00:00:01:11 - 00:00:20:43

Okay. It's now 11:05 and resume this issue specific hearing. And just check that. Teams is up and everyone can see and hear me clearly. Yeah. I'm getting the thumbs up at the back of the room. So apologies for that technical glitch.

Client: NORTH LINCOLNSHIRE GREEN ENERGY PARK LTD  
 Consultant: FICHTNER CONSULTING ENGINEERS  
 Project: NORTH LINCOLNSHIRE GREEN ENERGY PARK  
 Dwg Title: VERTICAL PARAMETER PLANS  
 ERF - NORTH ELEVATION

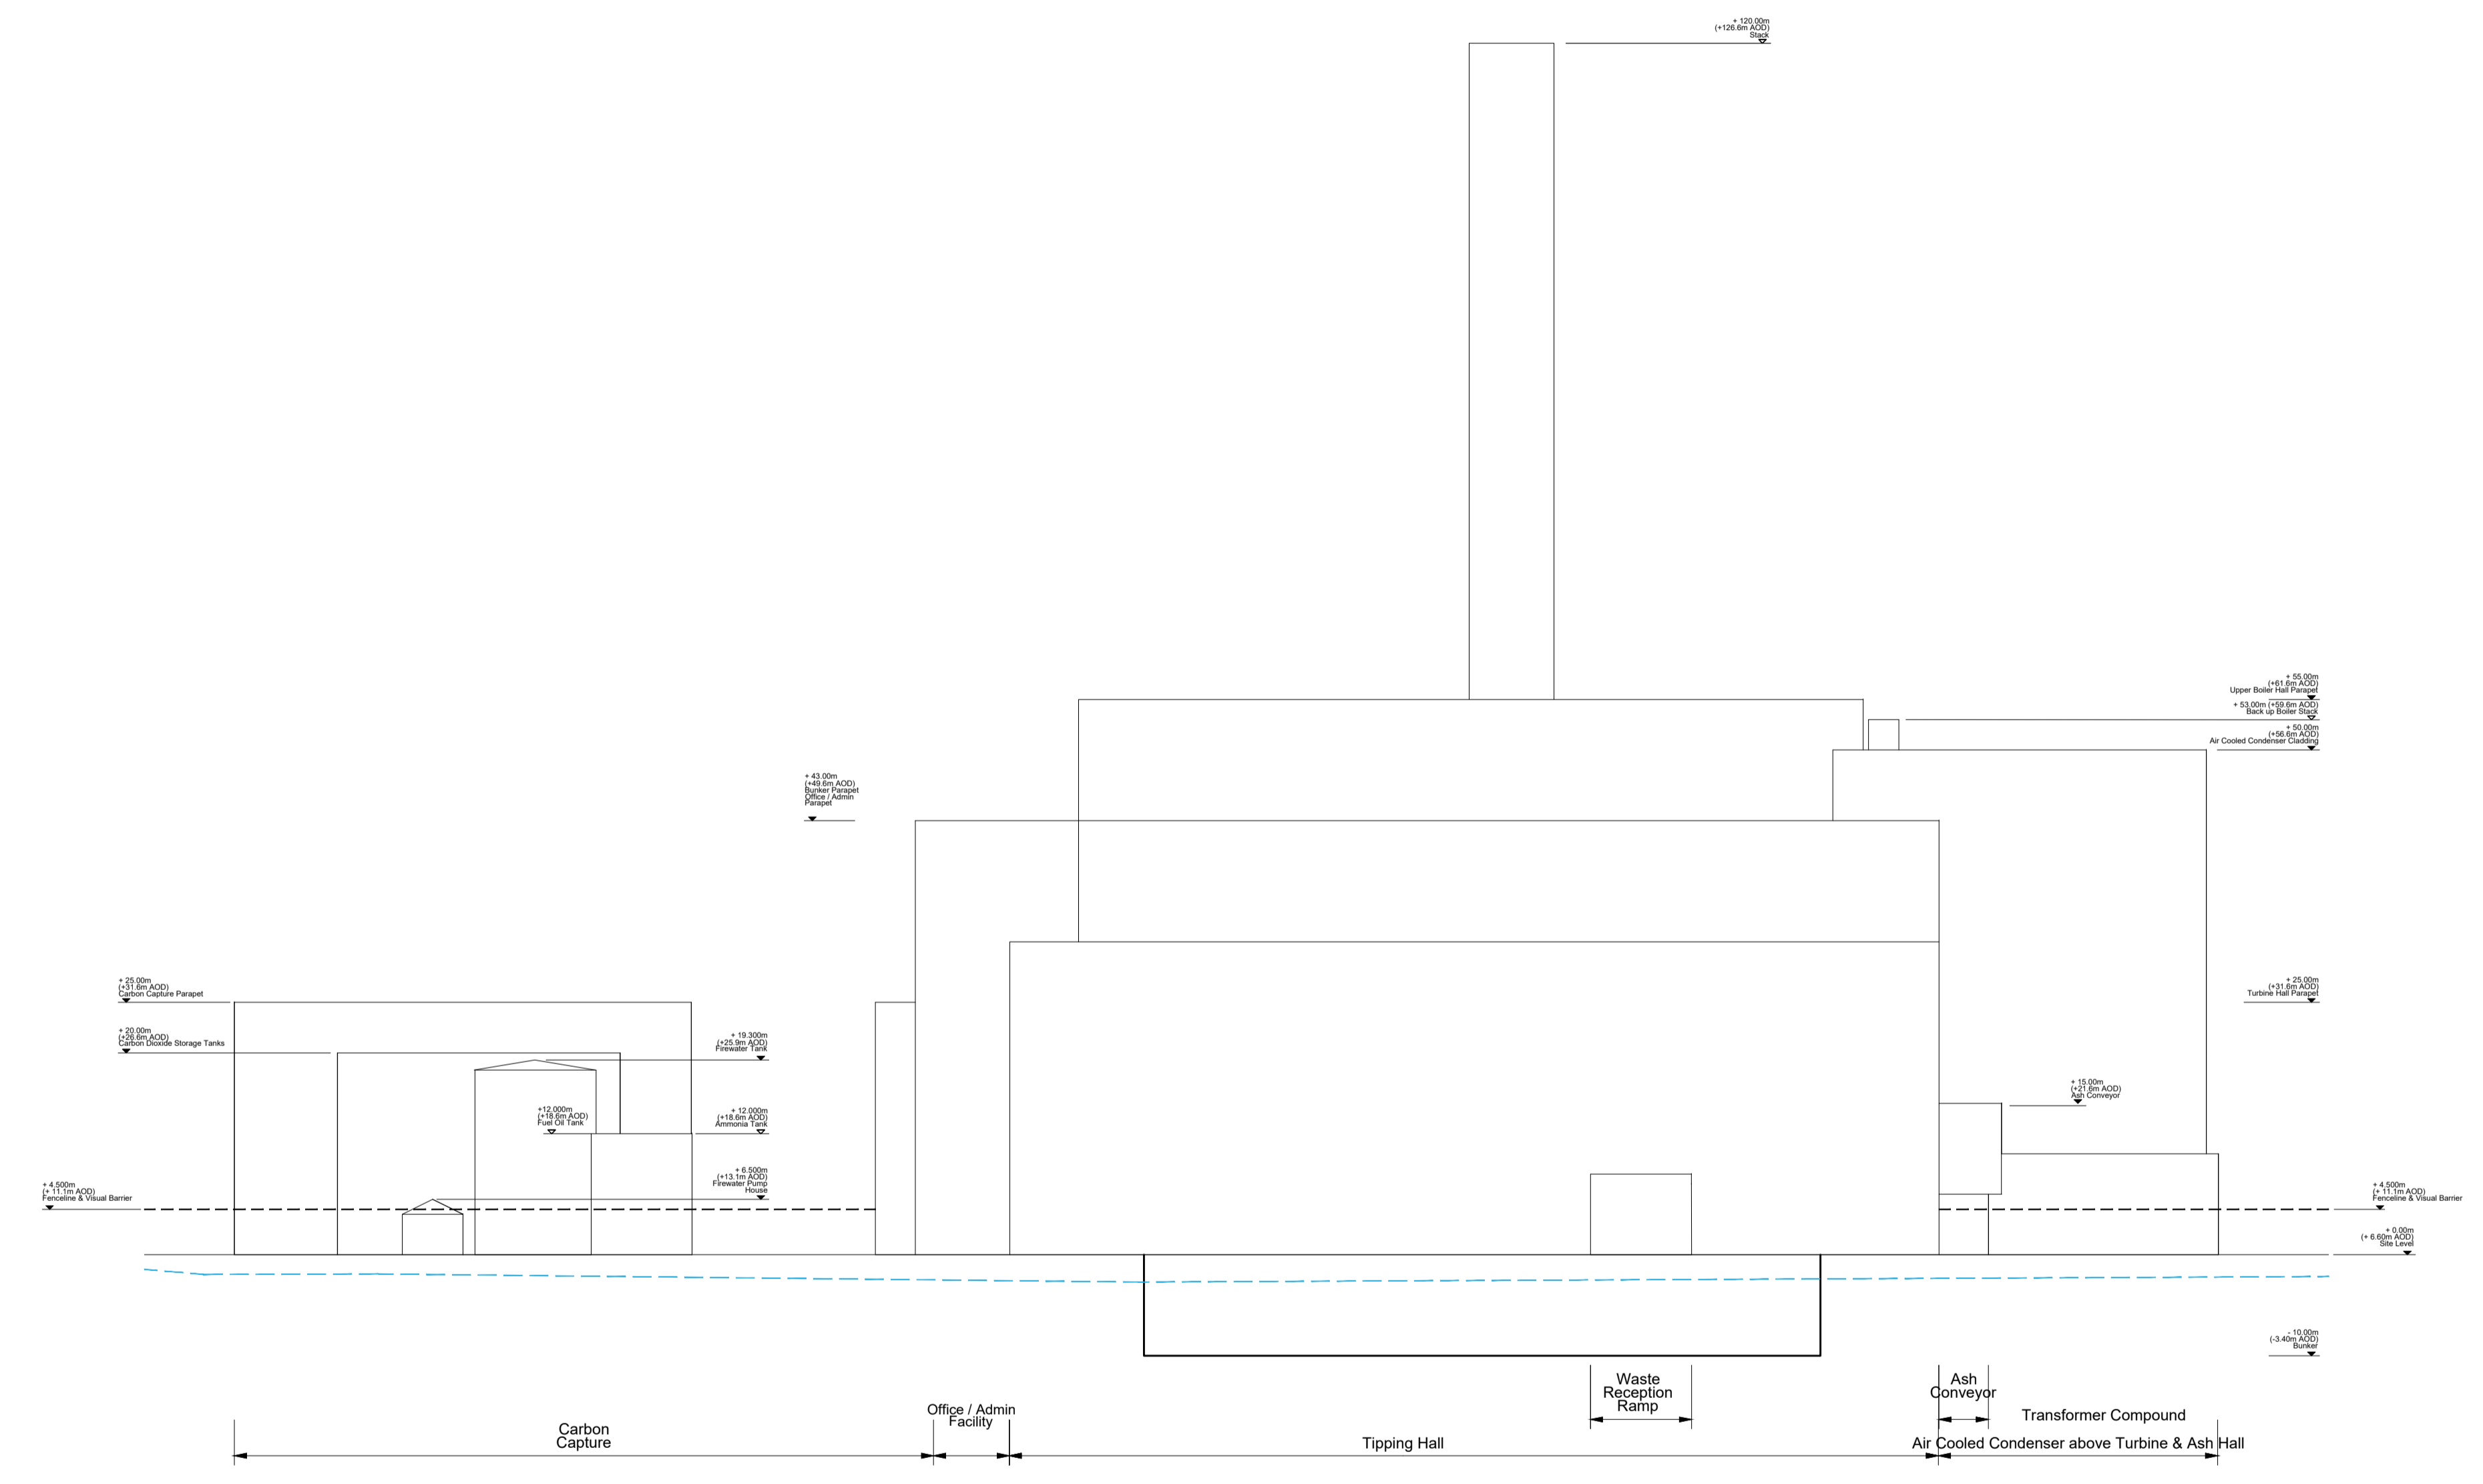
The visual barrier would be always proposed to be understand it's a minimum of three meters high, but at the current stage we don't think there's any maximum specified. And equally I don't know what the length of it is likely to be.

And so my sort of open question is, should that be part of the parameters included within the parameters table within the DCO? And I don't know whether you want to answer that or Ms. wants to or whether you want to defer that to consider it.

Thank you. Thanks. Rob Paul, on behalf of the applicant. That is correct. There is also a security visual barrier on the eastern side of the platform as well. To serve the same purposes as the Western. Okay. So is the description in Schedule one correct or should it be plural?

Because this 2 a.m. and I think it would be helpful if we go back to those section drawings, I'm assuming then there are two shown because there'll be one either side. Is that correct? Parliament half the applicant the the issue the section doesn't extend as shown on that diagram just then the section line doesn't extend all the

way across to the eastern side of the platform for the RF. So there won't be two visual barriers shown on the section due to the extent that is shown. Okay. But I think it emphasizes and I think everyone understands where I'm coming from in getting clarity from you as to the location of the barriers, their height and

length. And I think it would be sensible to have that clearly spelt out so everyone knows what it is that you're dealing with. And so hopefully that'll be something that you can do for the next deadline. On behalf that we take that way and just look at that wording and provide that clarity.

But that that's the the question I'm posing at Claybrook on behalf of applicant. I'm happy to start and we have been able to liaise with Mr. Powell during the break as well. In terms of the vertical parameters, we can certainly look at that in terms of defining a maximum and a minimum parameter and providing you with that

information should you require it then to form part of the parameters table and the schedule to the DCI? In terms of the lateral extent of the visual barrier, Mr. Powell has pointed me to the specific wording in the design process and codes document at para six six.

I previously referred to it DC AOC 502, which refers to the visually impermeable barrier and being at least three meters high. It stipulates that it is to be installed along the western and eastern edge of the development platform for the ERF.

So to a degree there are some descriptive parameters in terms of its extent and as I understand it, the precise length of it would be defined via the detailed design process pursuant to requirement three. That said, I'm reasonably confident as a consequence of that information that we ought to be able to define a maximum lateral extent by
